Responses to Public Comments on the Teanaway Solar Reserve Kittitas County, Washington

Prepared for
Teanaway Solar Reserve, LLC

February 2010

Prepared by
CH2MHILL

TYPICAL 20' ROAD SECTION

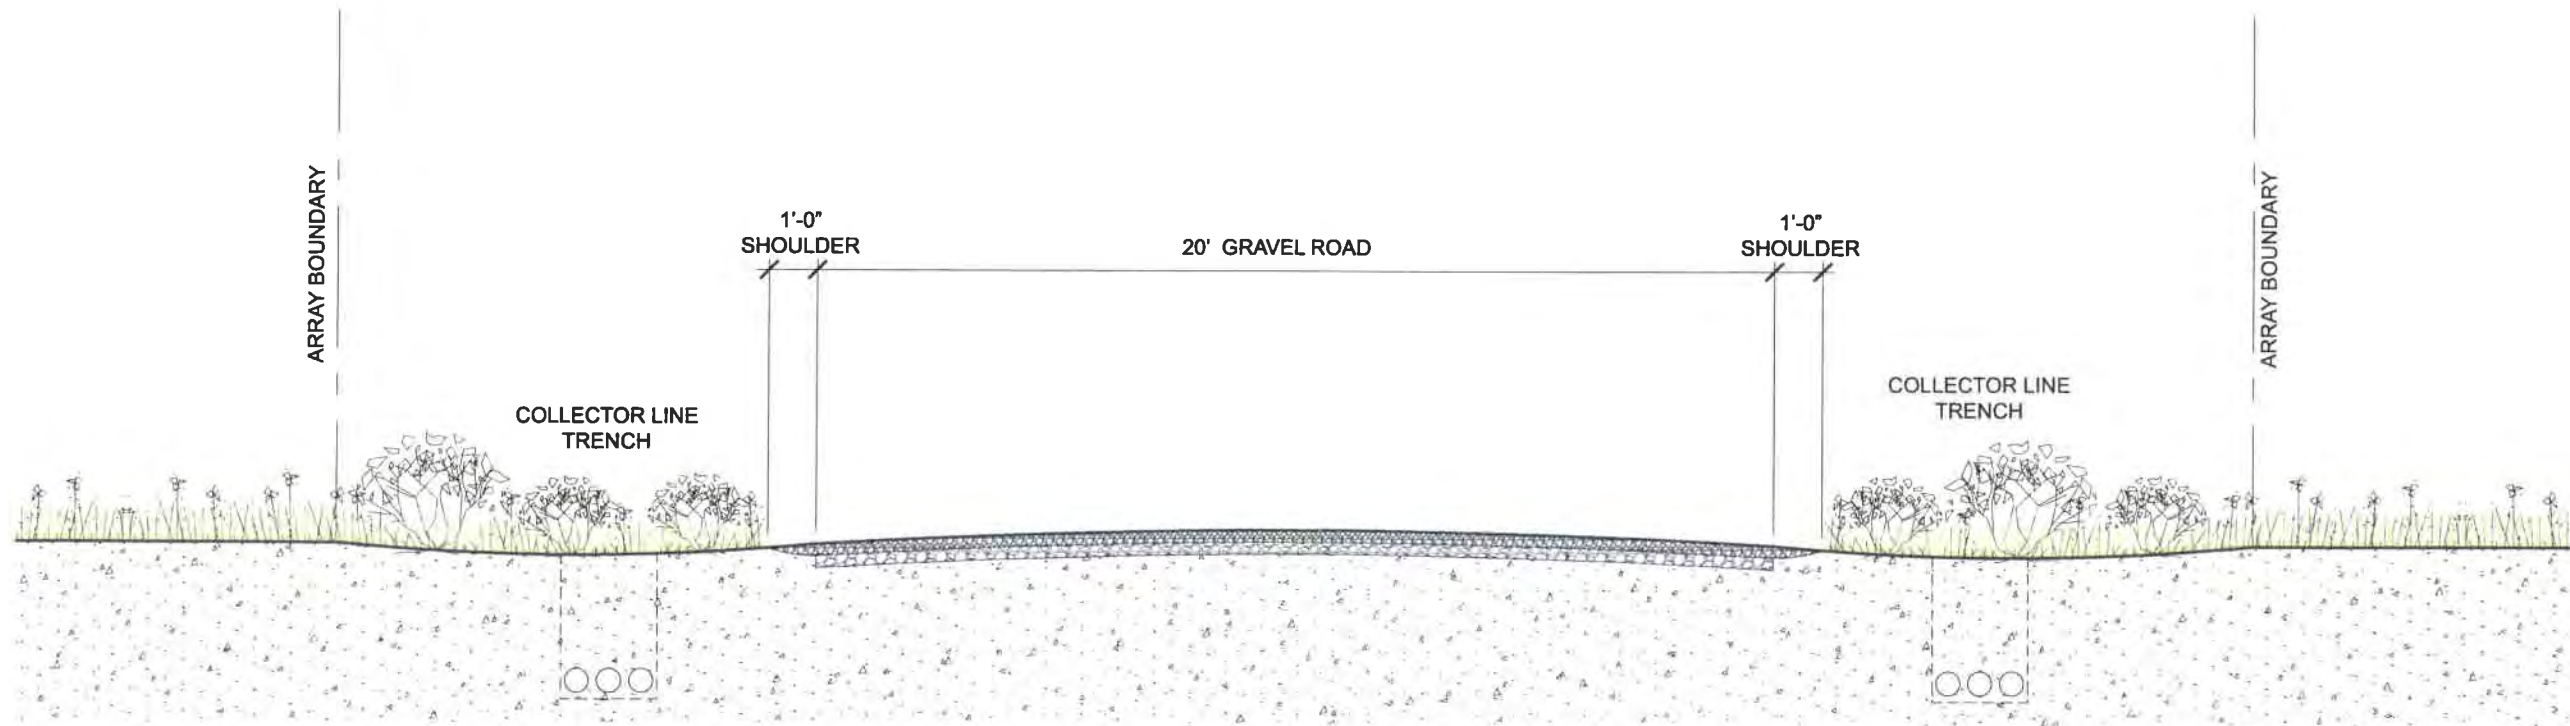
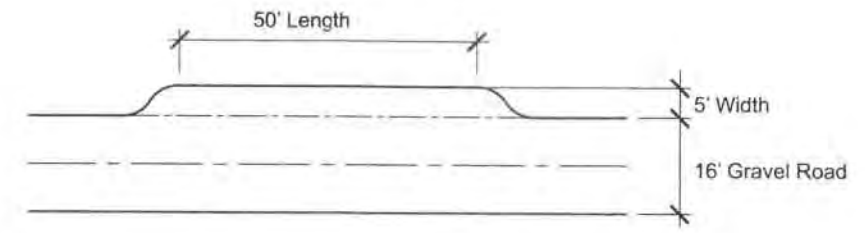
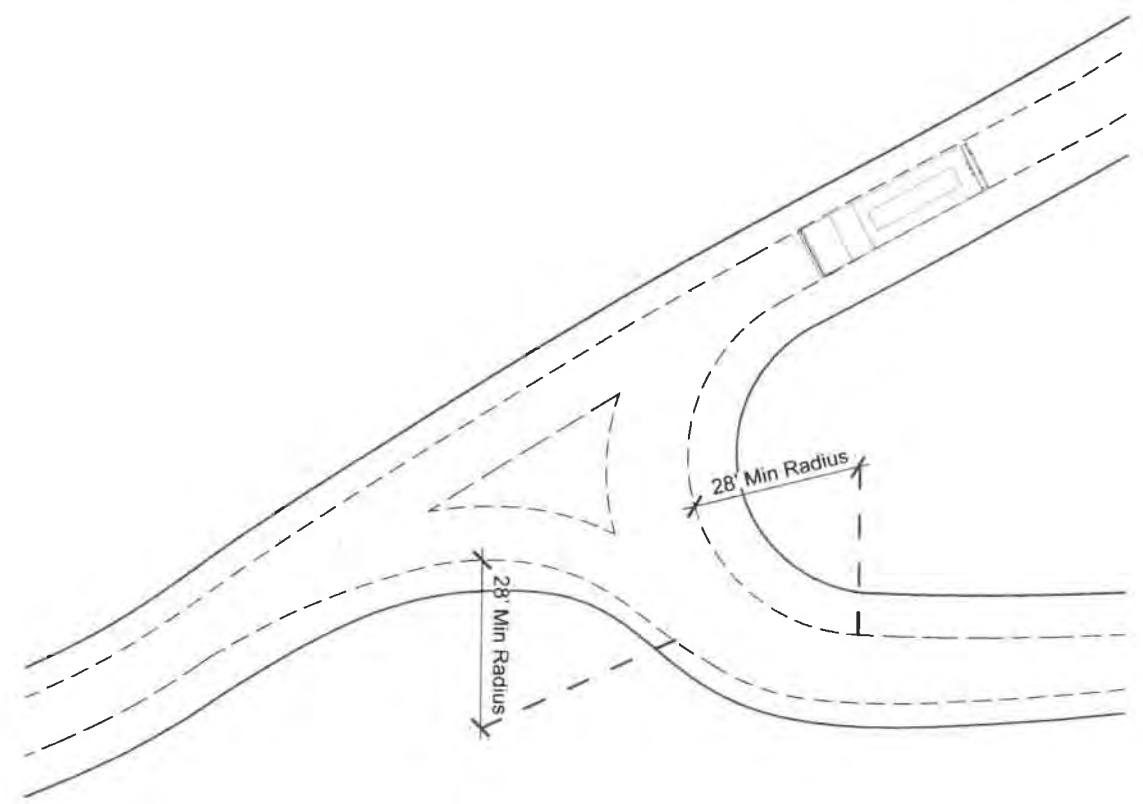
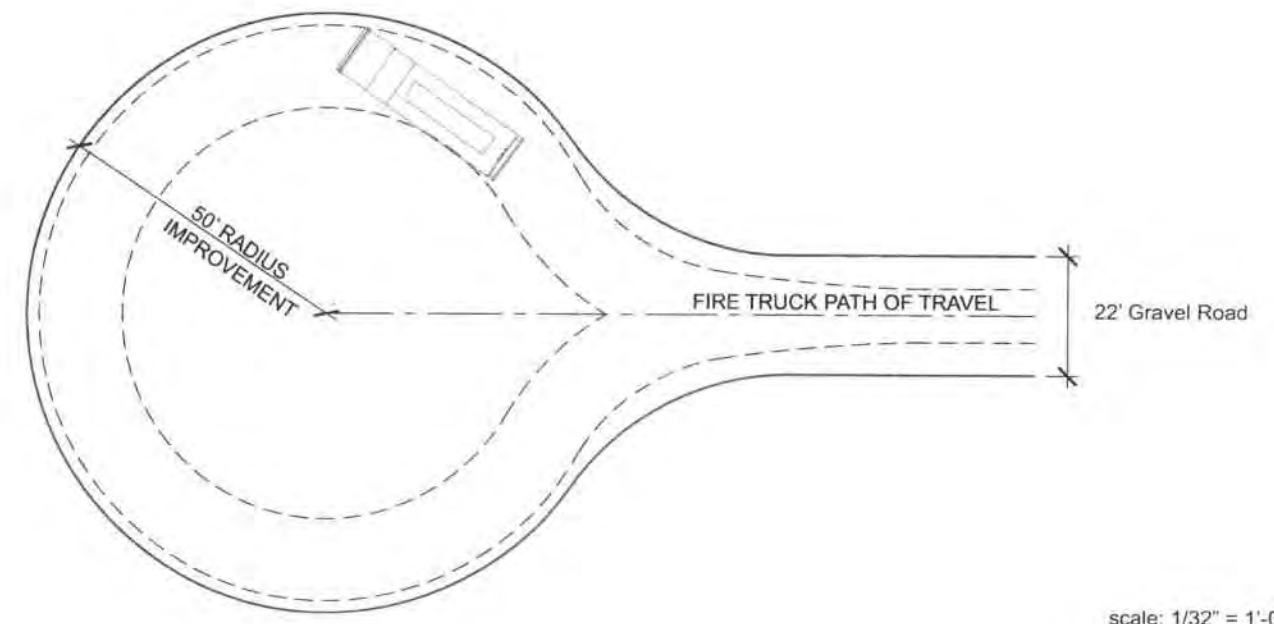
Comment 24	Compliance issues with fire code.	Public Services	Brenda Larsen Kittitas County Fire Marshal's Office 411 N. Ruby St., Suite 2, Ellensburg, WA 98926	September 23, 2009	The minimum road width shall not be less than 20' in width. In the event that the roadway infringes on a critical area, i.e. wetland, etc., provisions may be made to allow for a narrower road width in that area. All cul-de-sacs must have a minimum turning radius of no less than 50'. All development, design & construction shall comply with Kittitas County Code, Kittitas County Zoning and the 2006 International Fire & Building Codes. Due to the remote nature and topography of proposed project in this area, all new structures shall comply with the Wild-land Urban Interface Code requirements for defensible space and ignition resistant construction materials. In the event that sprinkler suppression systems and/or alarm systems are to be installed within the buildings, each system requires a separate permit from the Fire Marshal's Office. See Attachment 8 for complete letter.	TSR agrees with the Fire Marshall and shall incorporate measures into site design and road improvement plans.	A Transportation Road Plan is included as Attachment I of the Expanded SEPA Checklist Supplement. Figures are included as Attachment J of the Expanded SEPA Checklist Supplement. The Kittitas County Fire District 7 Contract is included as Attachment M of the Expanded SEPA Checklist Supplement.
